Project # 1002068

Project Name: Town of Atrisco Grant Unit 6

DRB Comments

RE: Lots 150 & 151, Town of Atrisco Grant Unit 6

SUBDIVISION DATA

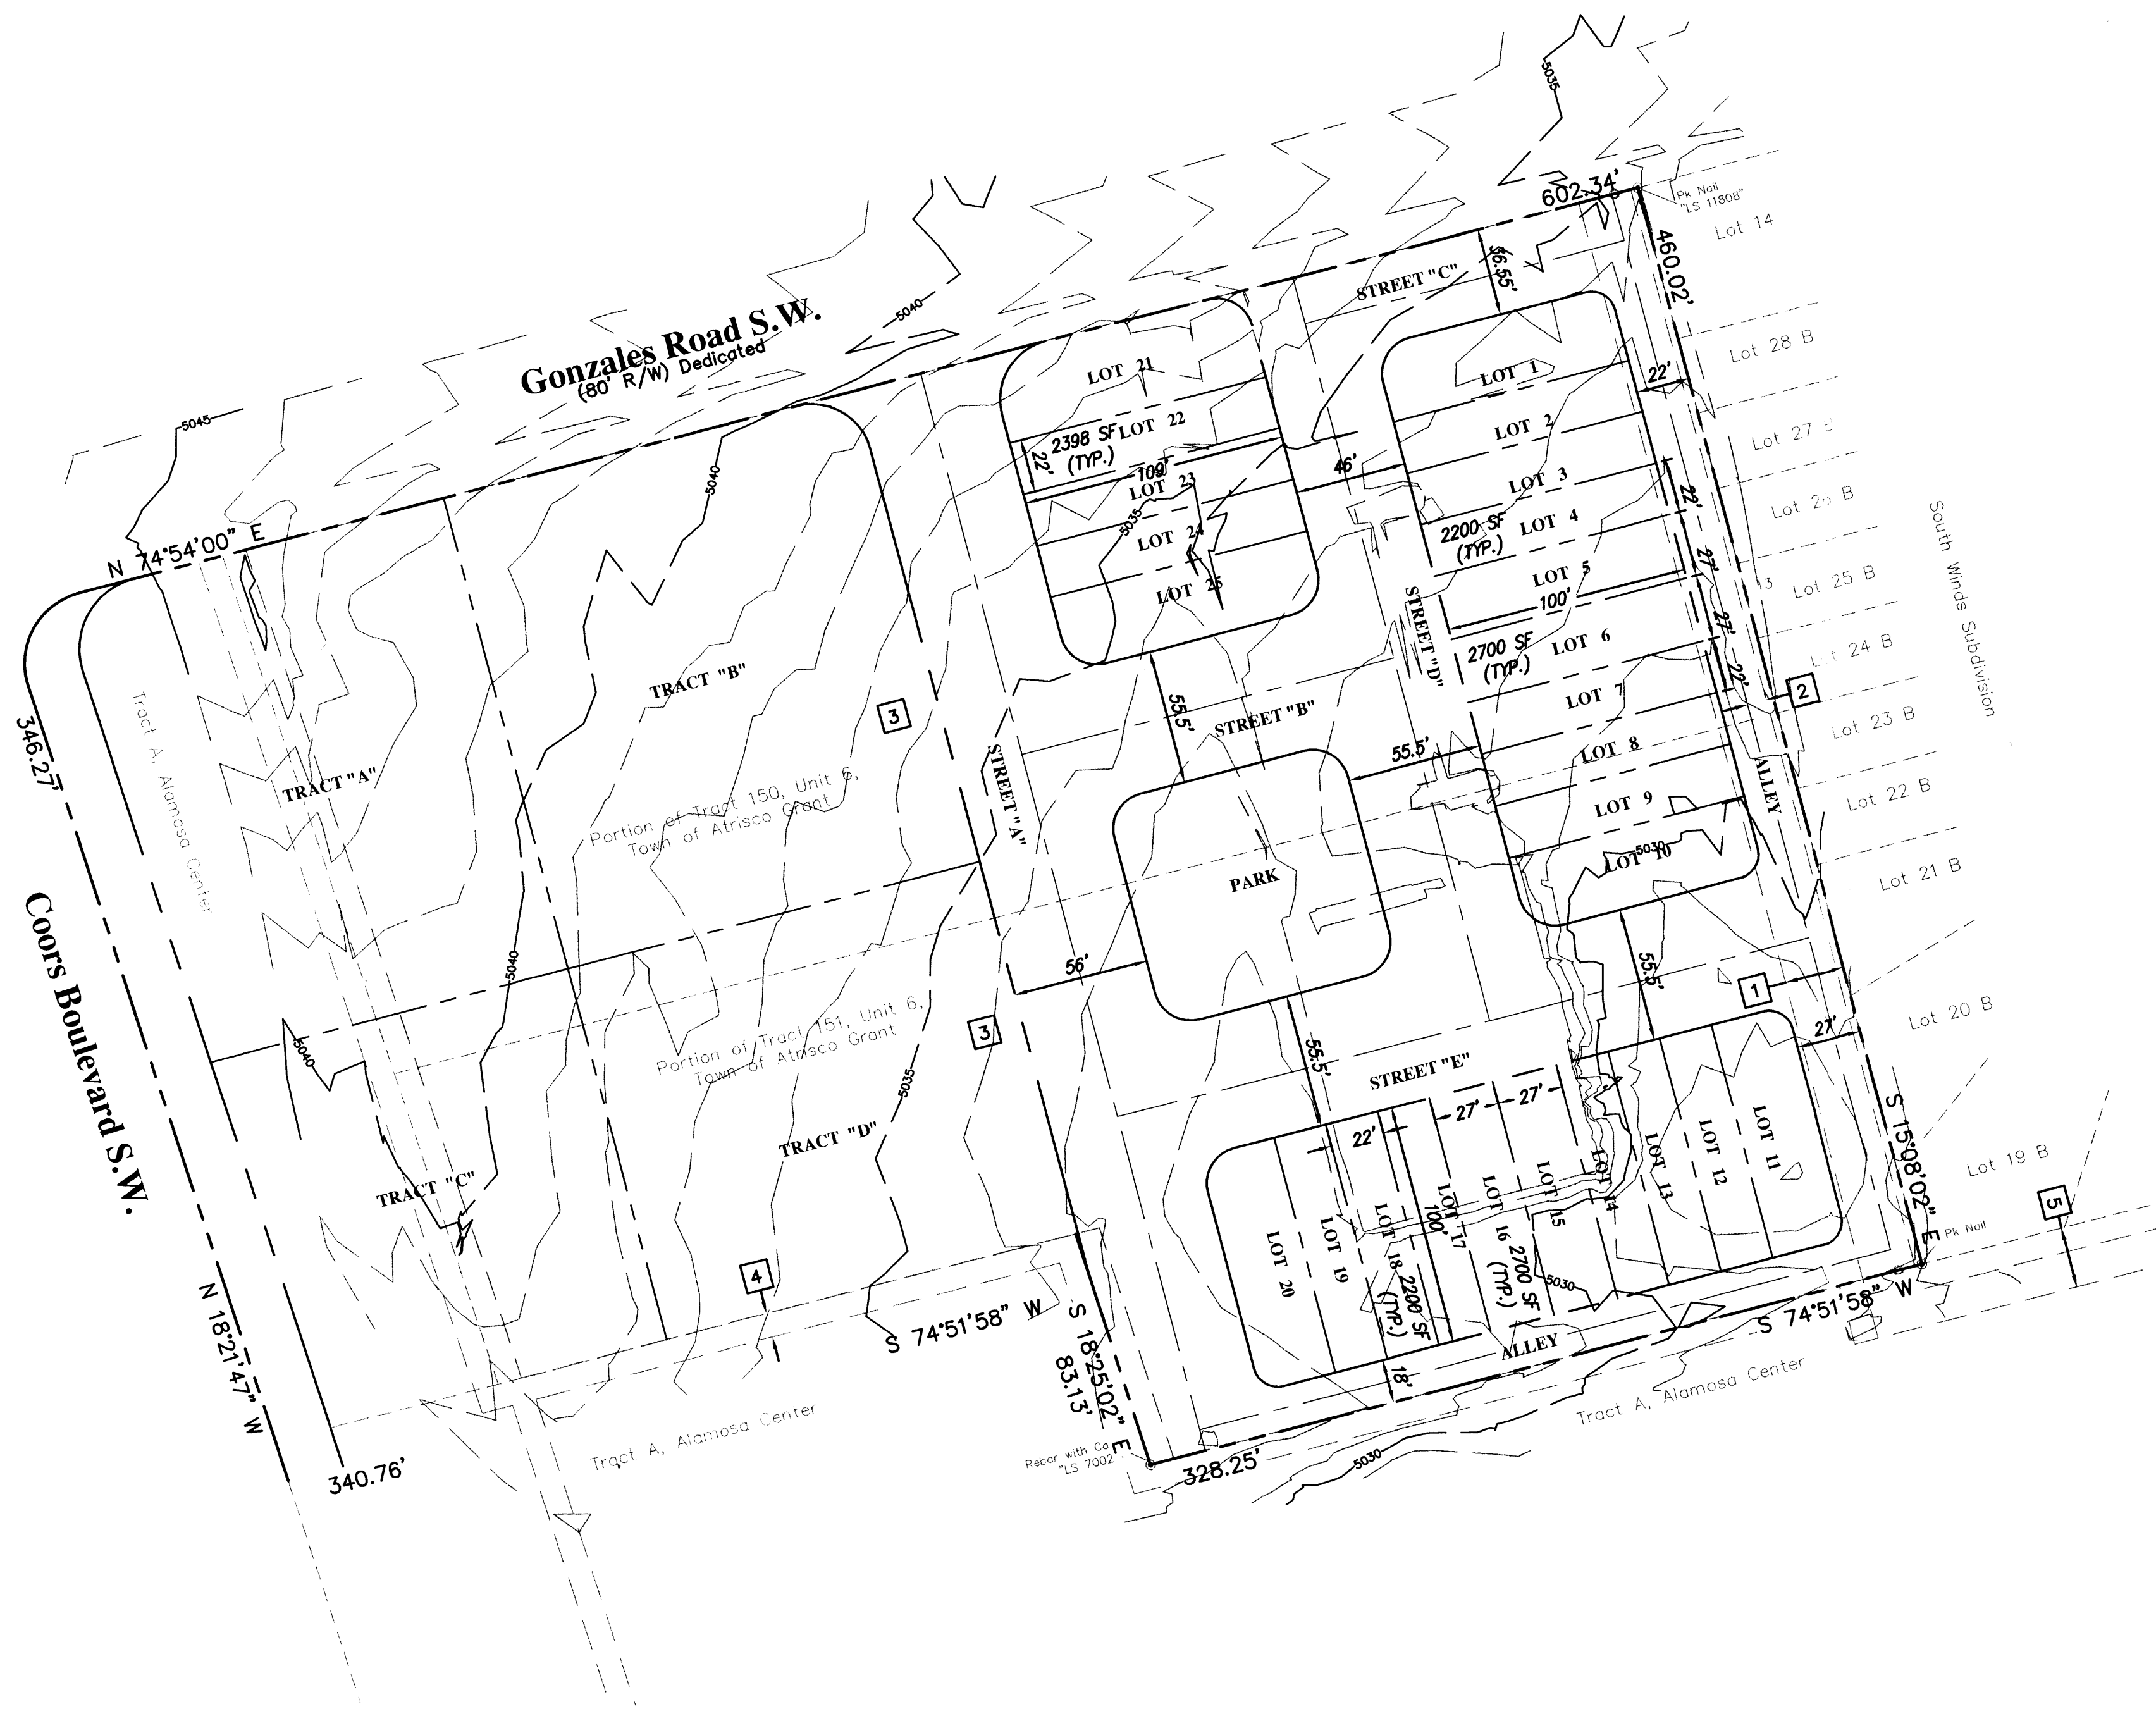
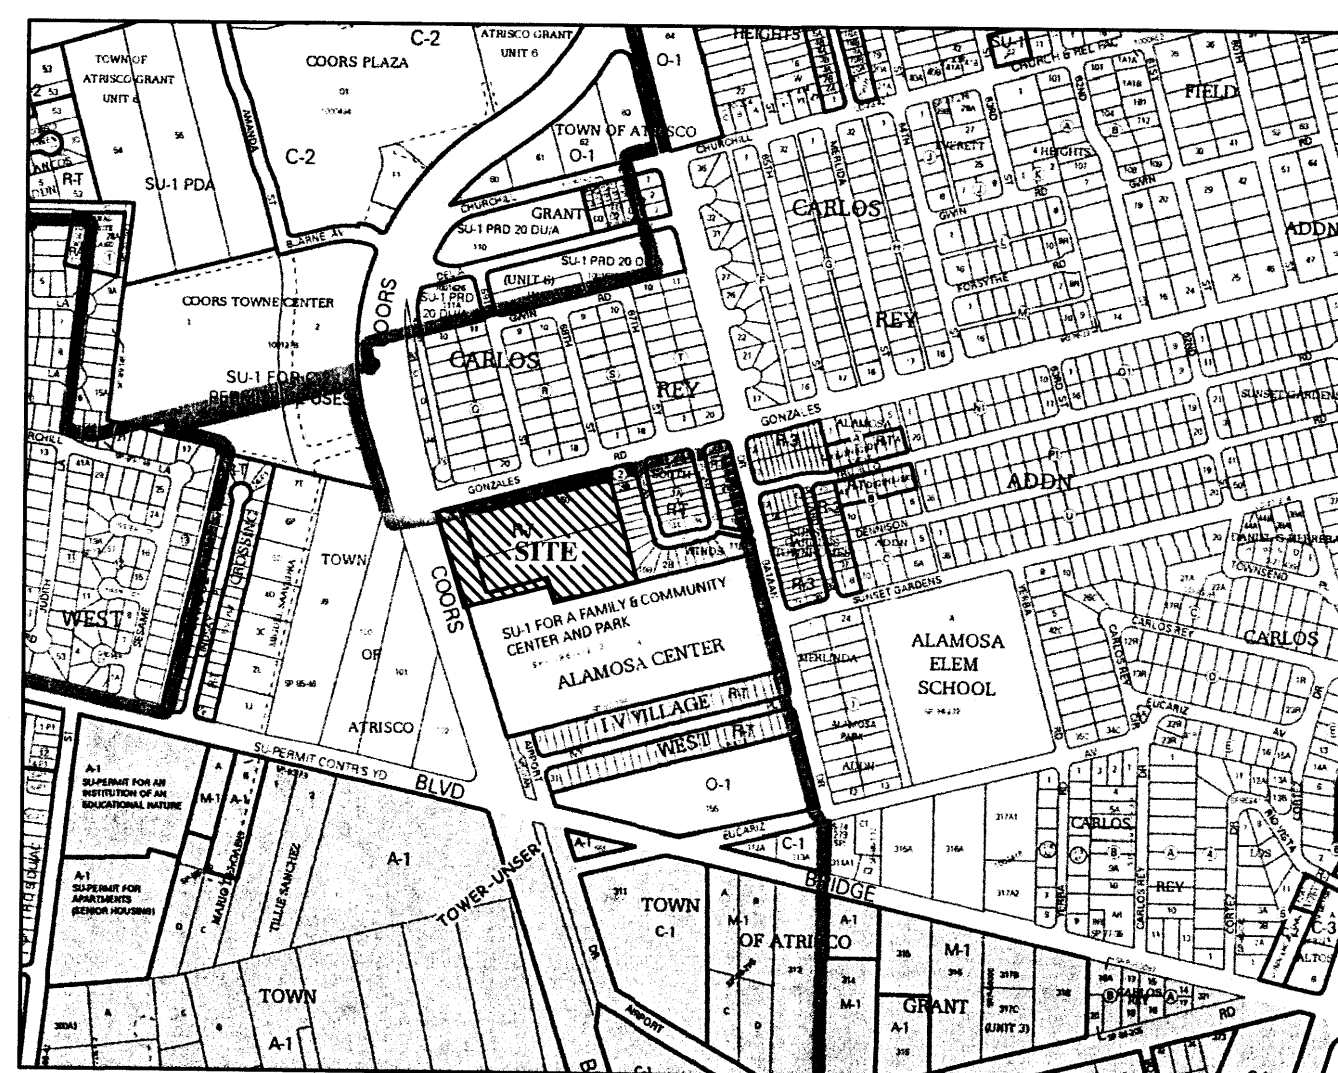
An approved drainage report is required for Preliminary Plat approval.
An approved infrastructure list is required for Preliminary Plat approval.
Probably need downstream, offsite drainage easement.

Provide an exhibit showing the location of sidewalk and defining the distance from face of curb to the property line. Right of way dedication may be required.

Geometric information (aisle widths, parking stall dimensions, all radii, slopes on ramps, etc.) must be provided prior to a complete review.

Please note that all proposed right-of-way, street geometry and roadway infrastructure must comply with the City of Albuquerque Development Process Manual and Standard Specifications. What are the lot designations and will they comply with the roadway widths?

Are the proposed streets private or public?

Street layout with alleys needs to be addressed along with DPM standards. The rear yard of the 5-lot block should not face the front yard of the residential block to the east.
